Application No: A/193/20/PL
Site Address: Ham Manor Cottage Ham Manor Way Angmering BN16 4JQ
Description of works: Erection of a 1 No. 3 bedroom chalet bungalow & detached garage. This site is in CiL Zone 3 and is CIL Liable as dwelling.

Thank you for your internet representation made on 14th February 2021 which has been recorded as an objection with the comments as follows:

I write to make objection to the planning application A/193/20/PL.

Proposed Street Scene (Scale 1:200)

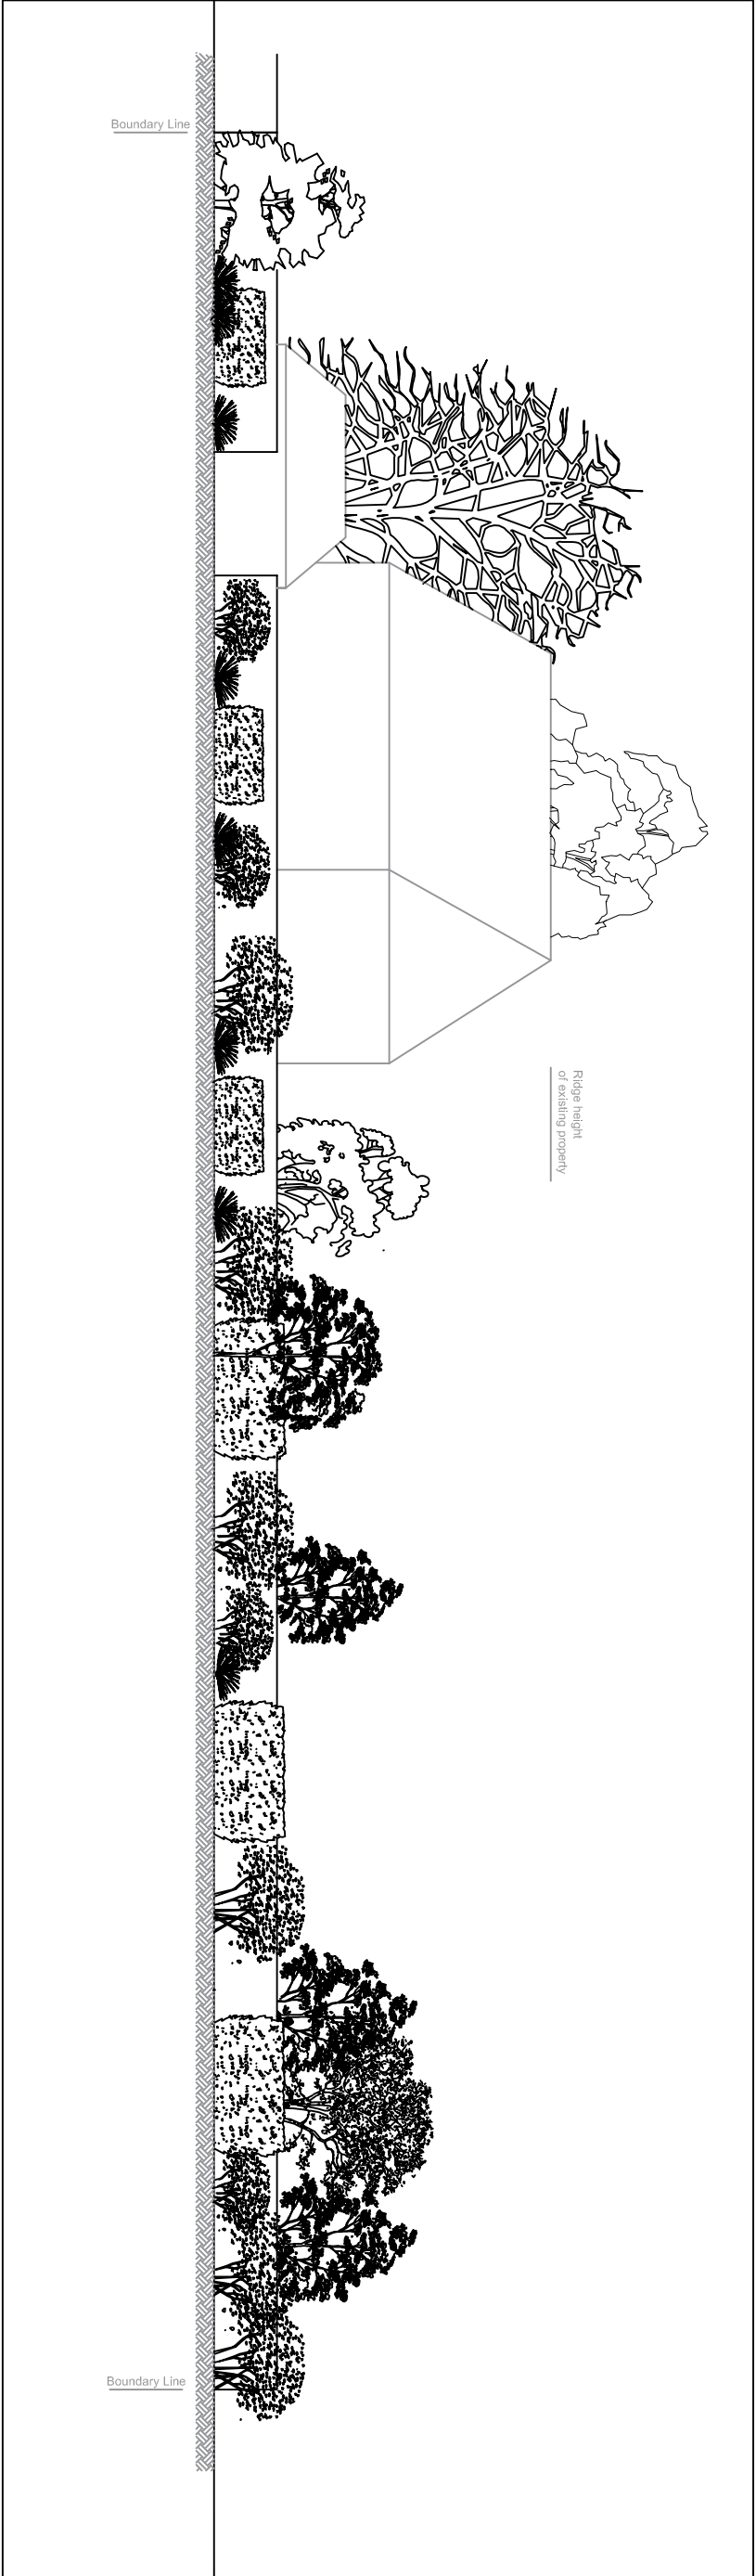
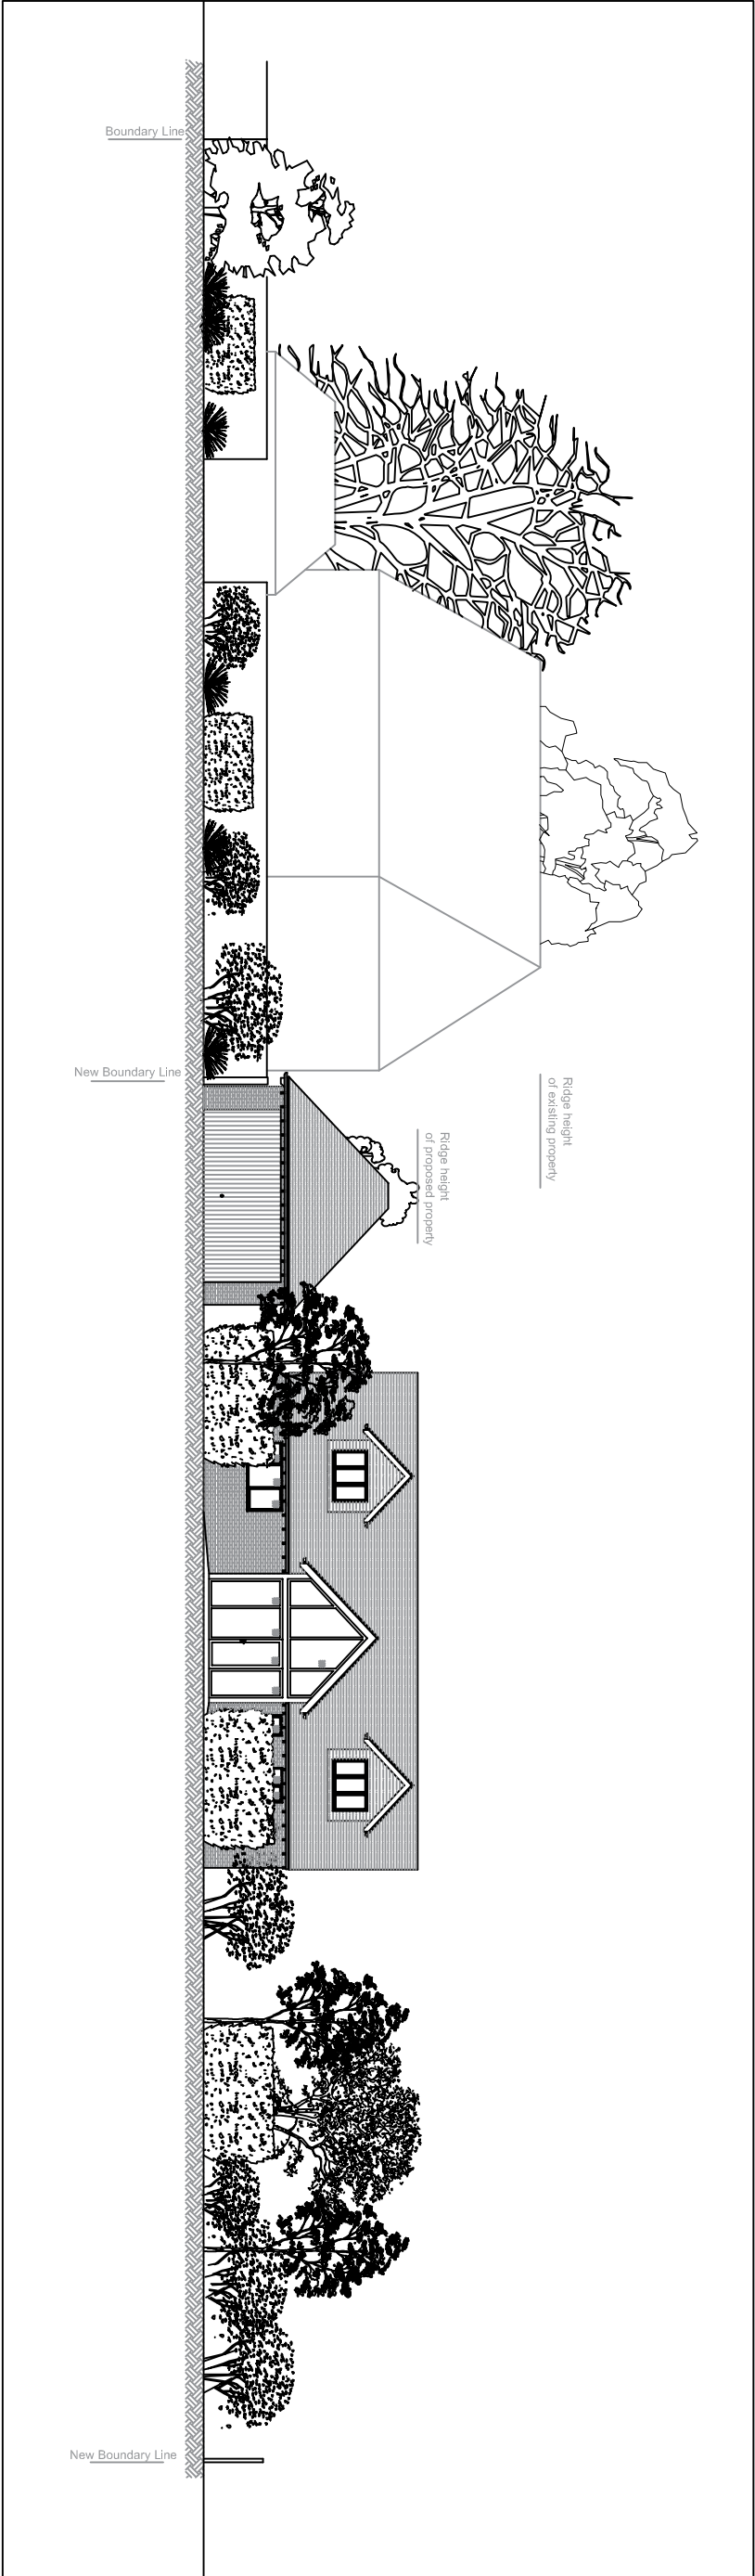
This application would not be a good fit with the surroundings, hemming in current properties further and reducing the rural style of the area and changing it into a high-density appearance.

The application is for a position of property forward of the historic building line which exists on both sides of Ham Manor Way thereby changing the street scene. Acceptance of this application would set a precedent for this.

Revision:	A	Dec 2020	Dimension added
address	Ham Manor Cottage, Ham Manor Way, Worthing, West Sussex		
project	Proposed construction of 3 bedroom detached property with detached double garage		
title	Proposed Block Plan		
scale	date	dwg no.	revision
1:200 on A4		2020.275.02	A

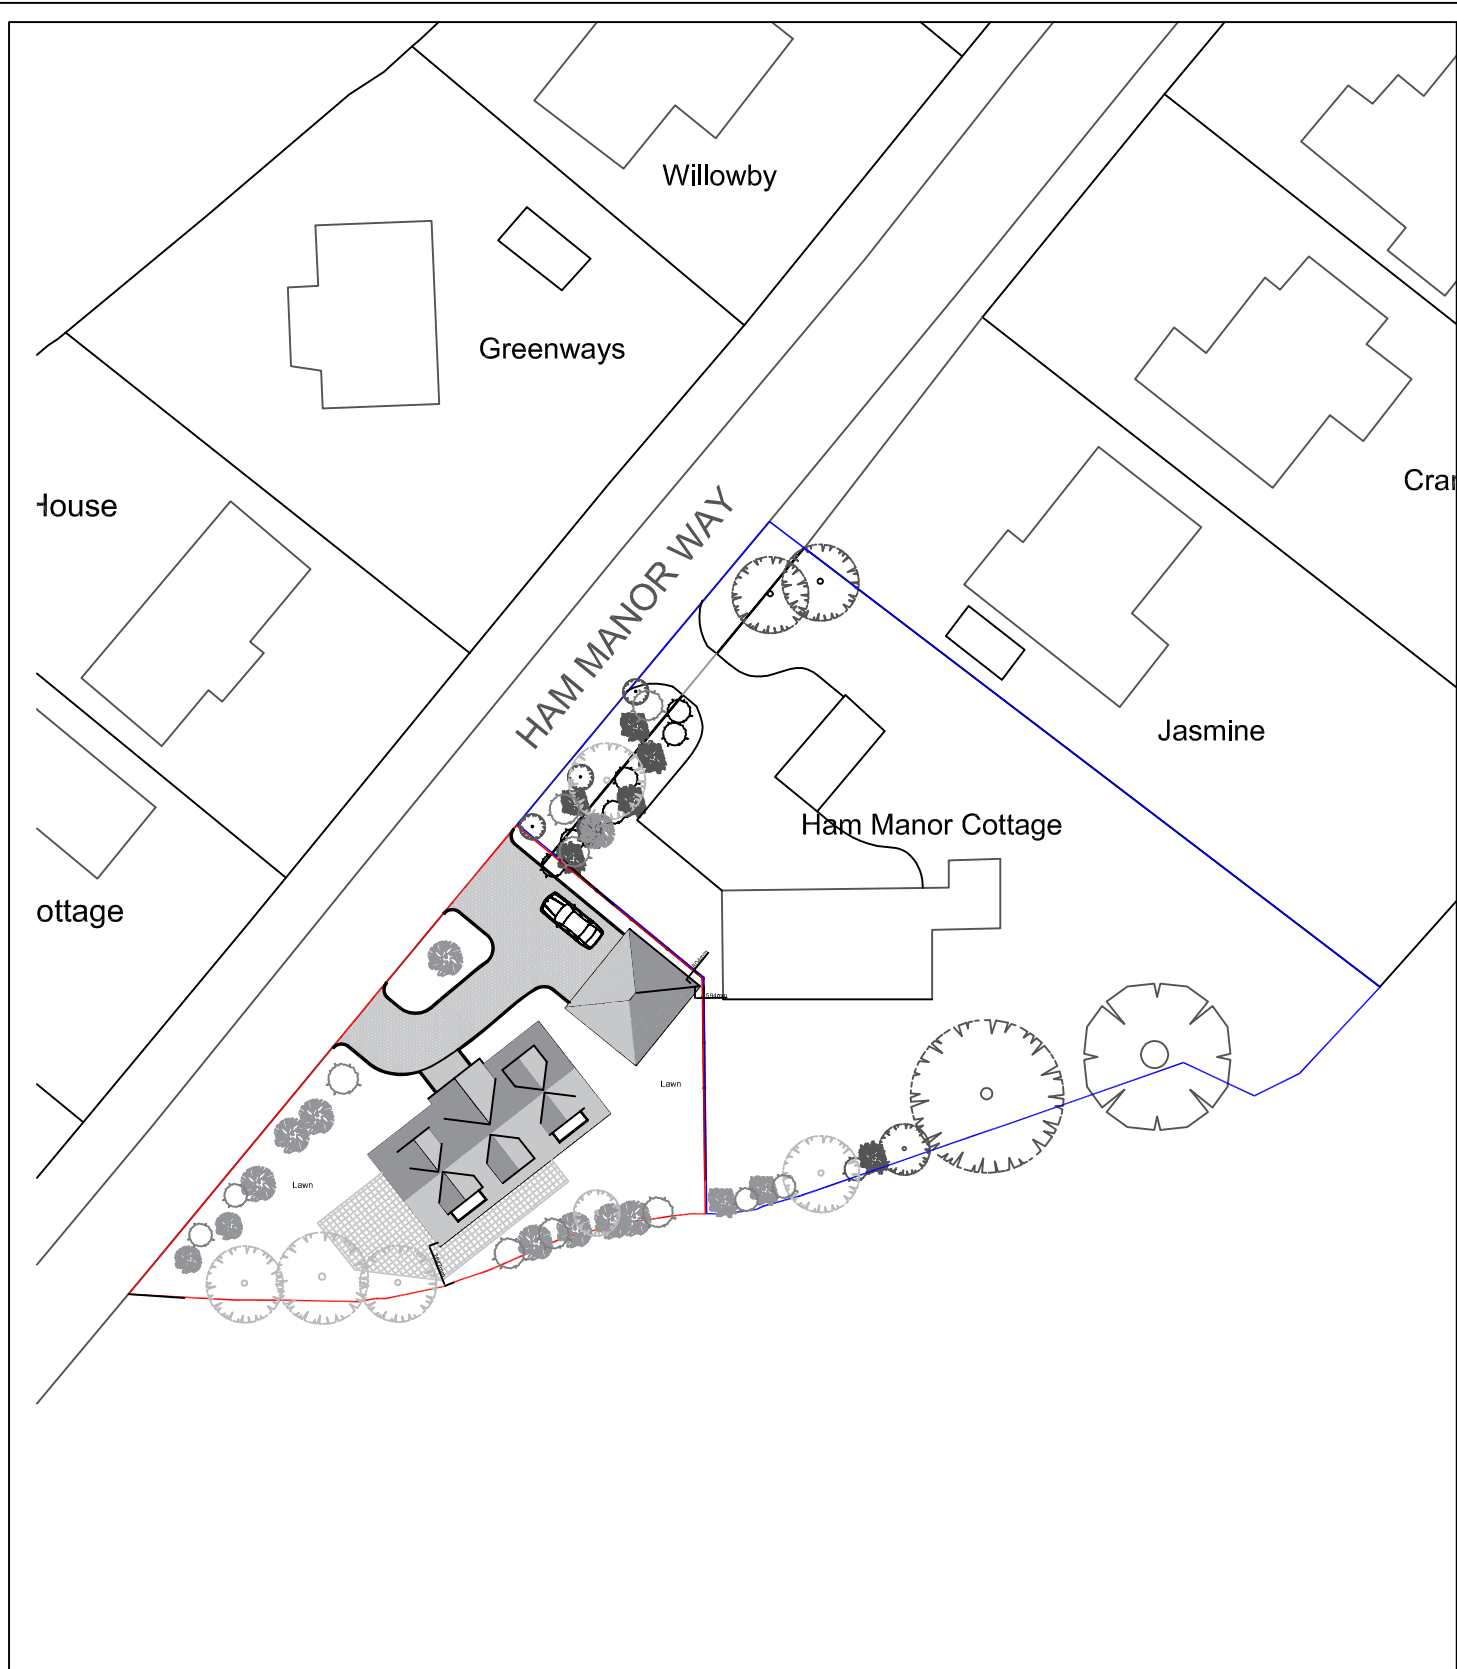
The application is for a house that is too large for the plot and does not match in with existing properties which are predominately low rise bungalows set in well-spaced plots. This application will effectively alter the current property and indeed the proposed property.
